**KIRKLEES METROPOLITAN COUNCIL
INVESTMENT & REGENERATION SERVICE**

DELEGATED DECISION TO DETERMINE PLANNING APPLICATIONS

Reference No: 2017/62/92564/W

Site Address: The Barn, 17, Jagger Lane, Kirkheaton, Huddersfield,
HD5 0QZ

PROPOSED SE ELEVATION

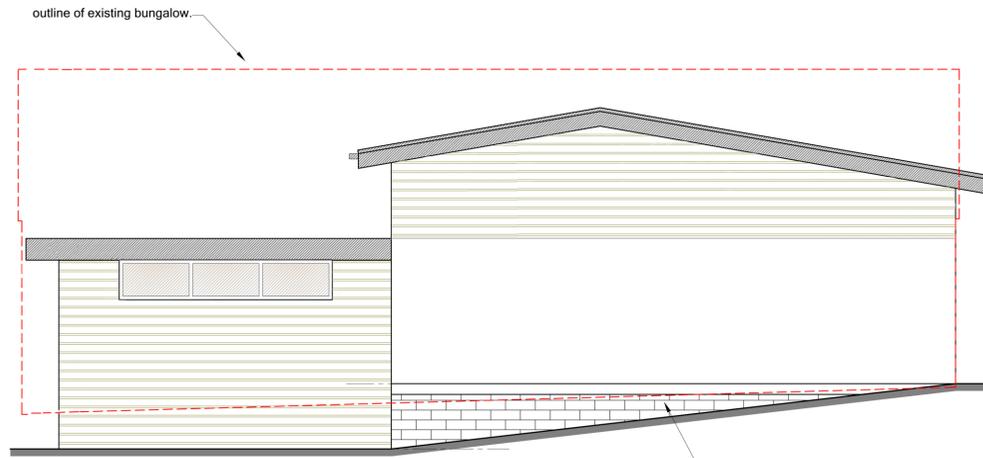
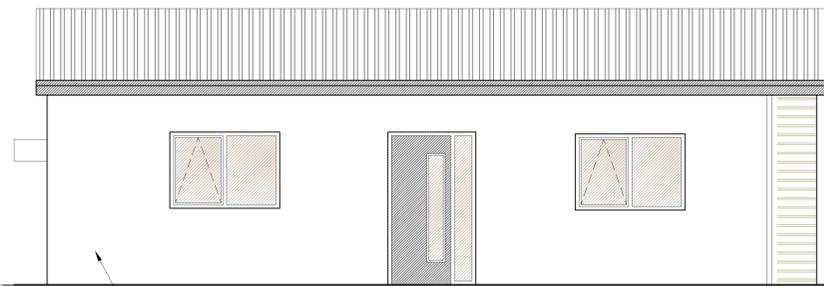
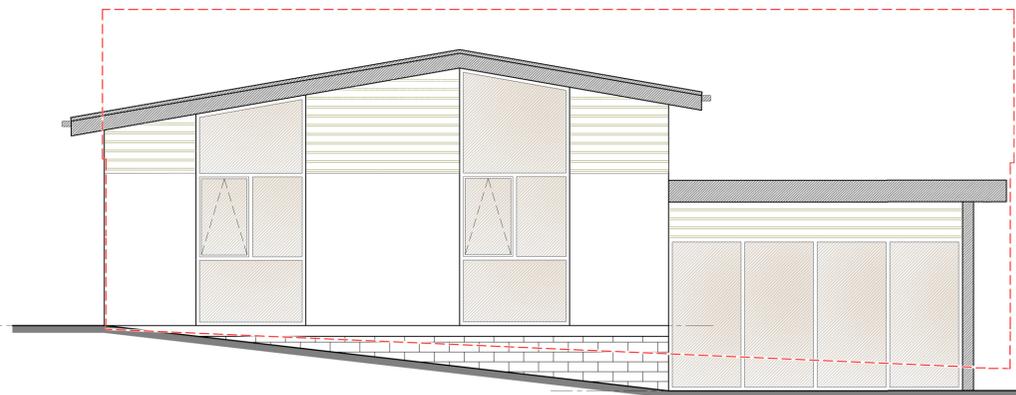
The design of the proposed dwelling is the same as the previous scheme although an additional window has been added to the front elevation which breaks up the expanse of walling to the right of the front door.

The design of the dwelling incorporates two distinct elements – an asymmetrical roof section and a flat roofed section to the rear.

I have reviewed the design of the development in light of the submitted design statement and the change to the fenestration on the front elevation. I have also paid regard to the justification for the material palette which is respectful of materials found on typical rural and agricultural buildings and I feel that this will in turn help to assimilate the dwelling into the landscape. On balance I feel that the design can be accepted. The proposal would therefore comply with Policies BE1 and BE2 and be compatible with PLP24 and chapter 7 of the NPPF, including para. 60.

neighbouring property belongs to the applicant. The dwellings would be separated by just under 9m. The south western side elevation of no.17 contains two sets of very large barn door style openings which serve an office and a master bedroom. The only windows proposed in the side north eastern elevation of the proposed dwelling is a high level window serving the open plan living area.

Given that the only window facing no.17 is a high level window I am satisfied that there would be no direct overlooking.

GROUND FLOOR PLAN

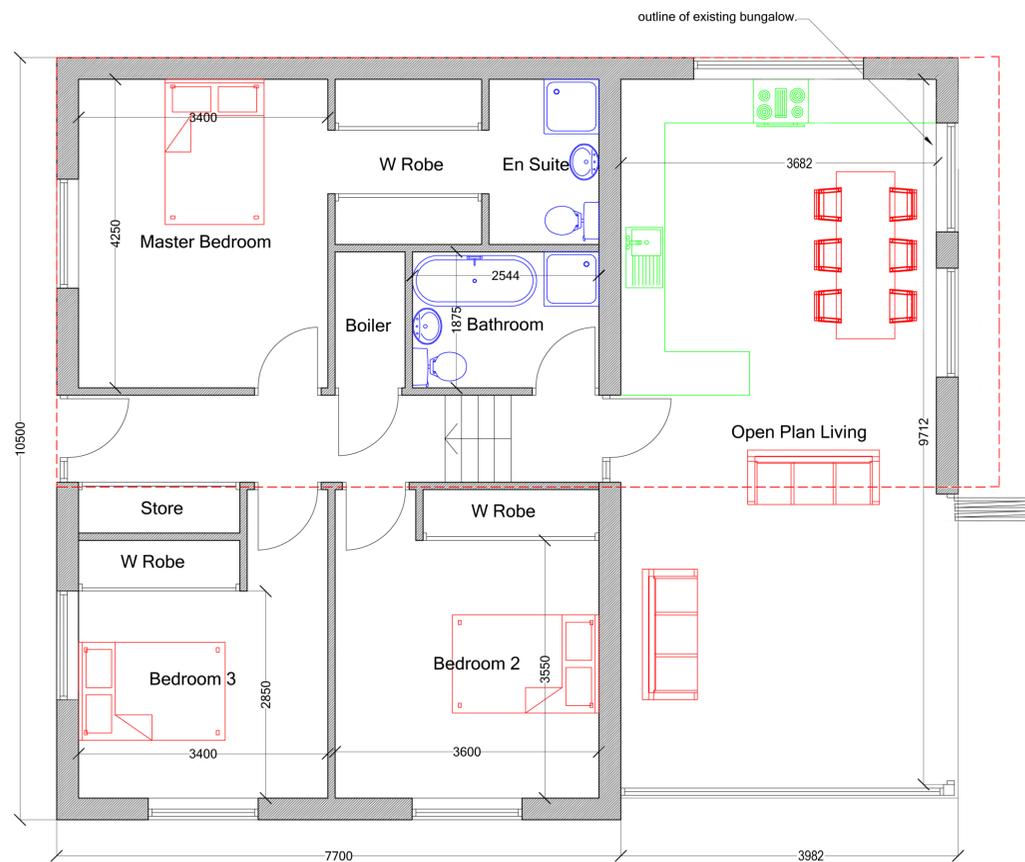
The submitted plan shows the proposed dwelling relative to the existing pitched roof outbuilding; this demonstrates that the dwelling would be slightly lower in height than this existing building and would be of a similar length. It is accepted that the width of the building is much greater. The supporting statement provides some volumes for the existing outbuildings and proposed dwelling. This indicates that the existing outbuildings amount to 338 cubic metres and the proposed dwelling has a volume of 338 cubic metres. Based on this information I am satisfied that the scale of the proposed dwelling would not have a materially greater impact on the openness of the Green Belt than the existing buildings. I do however consider it necessary and reasonable to remove permitted development rights for extensions and outbuildings in order to preserve the openness of the Green Belt in the future.

5. The buildings identified as 'existing buildings to be removed' on approved drawing number 1284-15-005 Rev B that lie to the south east of the new dwelling shall be surveyed for the presence of bat roosts by a suitably qualified ecologist and the findings of the survey submitted to and approved in writing by the Local Planning Authority before the buildings are demolished.

6. The buildings identified as 'existing buildings to be removed' on approved drawing number 1284-15-005 Rev B that lie to the south east of the new dwelling shall be removed pursuant to the requirements of condition 5 and before the main roof structure of the dwellinghouse is completed. The buildings shall be removed in their entirety and the ground where the buildings stood (where it is outside of the application site boundary) shall be seeded within the first available planting season and thereafter left as open grassland/meadow.

LOCATION PLAN 1:500

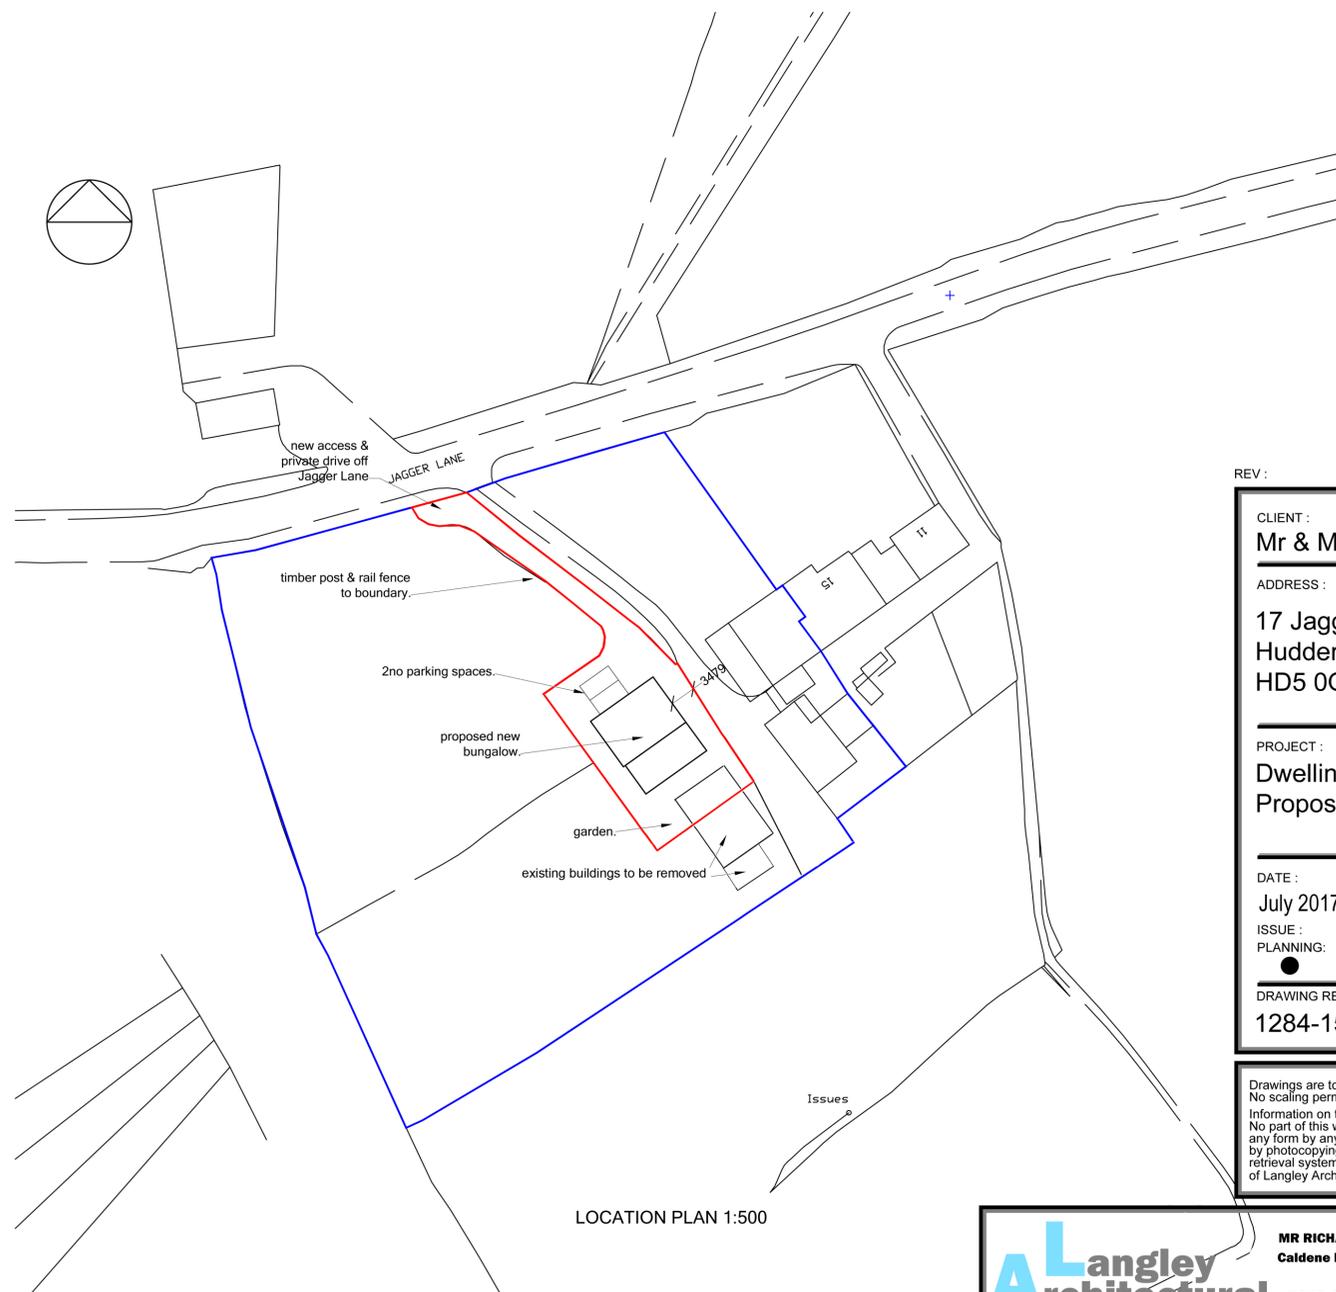
The site plan indicates a timber post and rail fence to the boundary; these are typically relatively low in height (circa 1.2m) and such boundary treatment would help to maintain the openness of the Green Belt and respect the character of the area. This boundary treatment can be conditioned. The vehicle access would be crushed stone which would respect the rural character.

Response: The site plan shows a post and rail fence; this is considered to be an acceptable boundary treatment and would retain more of the open aspect of the land.

4. The external boundary treatment of the site shall be a timber or metal post and rail fence with a maximum height of 1.2m. The boundary treatment shall be installed before the dwelling is first occupied and thereafter retained as such. Notwithstanding the provisions of the Town and Country Planning (General Permitted Development) Order 2015 as amended (or any Order revoking or re-enacting that Order with or without modification) no other fences, walls or other means of enclosure shall be erected to the external site boundaries without the prior written consent of the Local Planning Authority.
